DECISION DELEGATED TO HEAD OF PLANNING

Application No: H16-1179-20 **Applicant:** Mr Wilson

Proposal: Erection of 9 dwellings - outline approval H16-0193-19 as amended by Section 73 consent H16-0710-22

Location: Land South East Of Littleworth Drove Lucks Bridge

Drwg Title: **Block Plan**

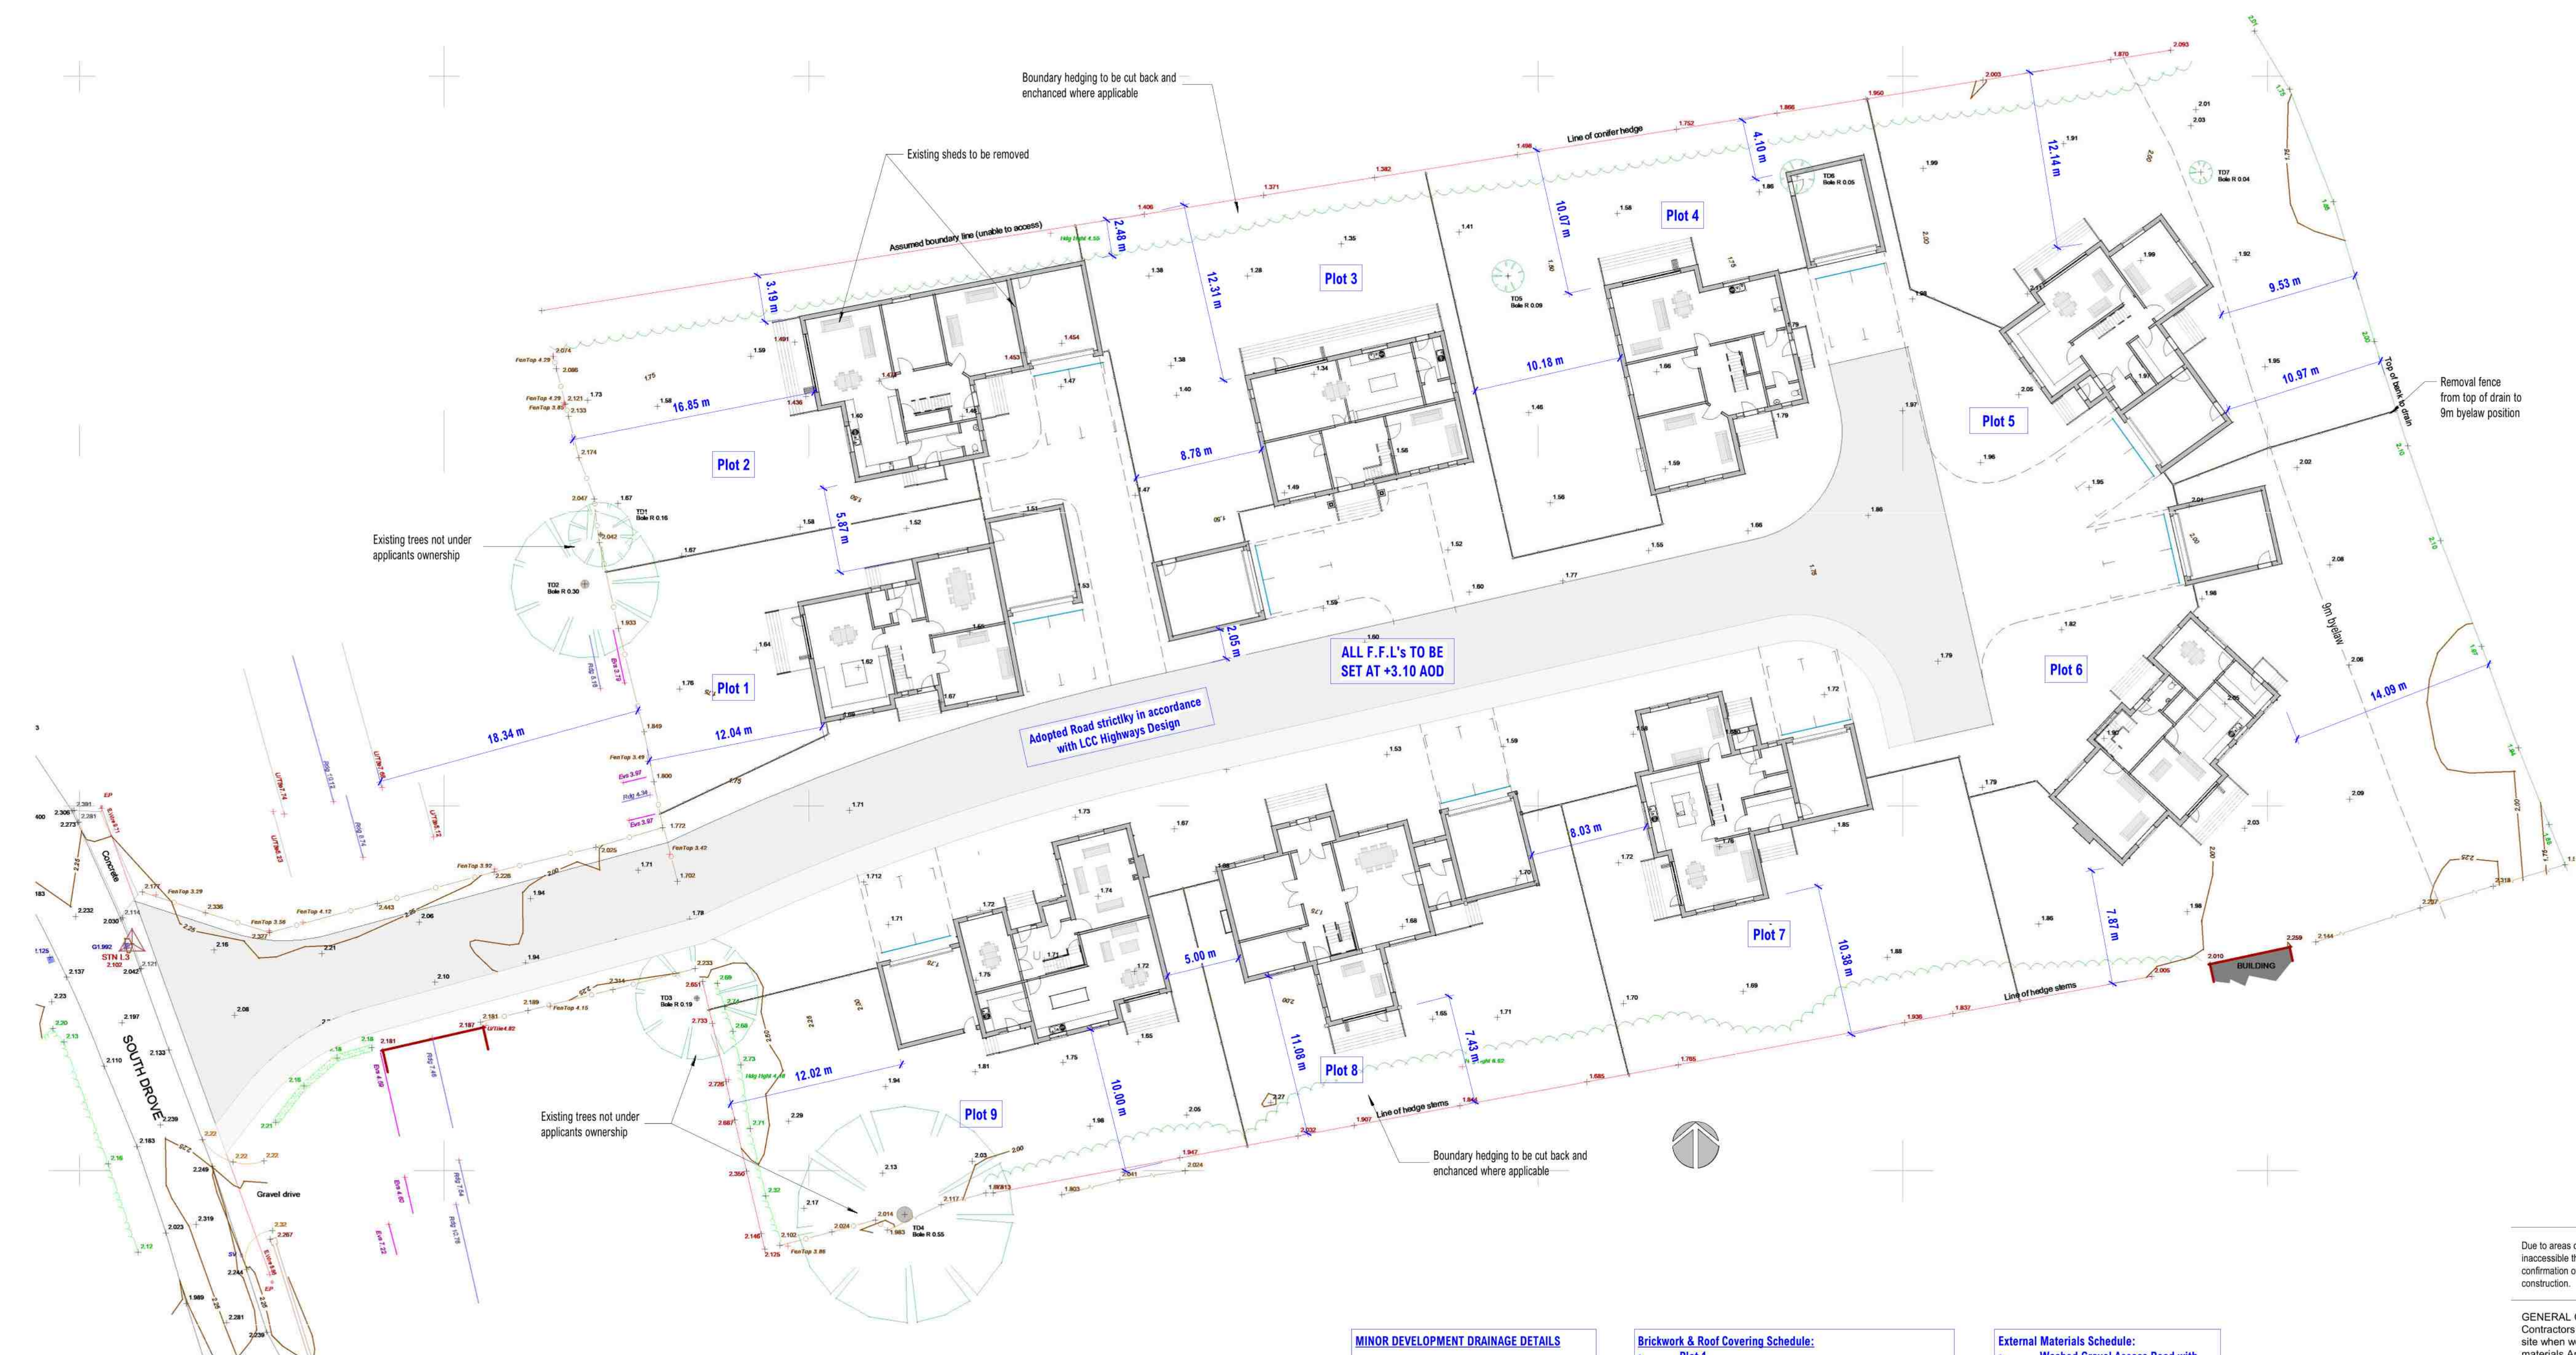
The proposals for this development includes a collection point from where the new road joins with South Drove. I believe that South Drove is an adopted road, whereas this development will remain a private roadway and therefore not accessible by our refuse vehicles. In principle a collection point would be the way to ensure we could collect the waste from these properties, however in this instance there are many difficulties with this proposal including;

- Size of scheme which would result in build-up of large volumes of waste presented at the collection point
- Length of roadway that will mean residents have to carry waste over 30m, as stated on the plans
- Proposal to provide flat beds for waste transportation is problematic and we would be interested to understand who will be responsible for maintenance and replacement of these
- Collection points can be challenging at best of times for early presentation and which scheme of this size that risk seems to be higher than usual
- Therefore there is likely to be a negative impact on the locality including current neighbours and those passing this collection point.

However, Condition 14 of the Outline Consent for this development requires that the road be adopted as public highway. Please be advised that the geometry and the construction shown on the submitted details do not meet the requirements for highways to be adopted by this Authority.

Also, Condition 16 of the Outline Consent requires that the development be drained by means of sustainable drainage principles. There does not appear to be a drainage strategy submitted in this Application save for a few words on the layout drawing advising that all rain water is to be discharged to soakaways that are to be a minimum of 5.0 metres from any building. That does not constitute a drainage strategy.

Object - It seems more obvious under this most recent application that the intention is to use the Board's strip as garden space and to put fences across this space running directly to the top edge of the Board's Fantail Drain. This objection subsequently removed by response to a subsequent consultation.

The application has been revised since submission to change the dwelling designs, to include landscaping and to resolve the matter of refuse collection as well as management and maintenance responsibilities. In addition, a gate for access for the Internal Drainage Board has been included.

No objection subject to conditions regarding submission of a Construction Management Plan, and informatives.

No objections. Access gate and access strip treatment to be conditioned.

A gated access for IDB access is required and this is approved by condition submission.
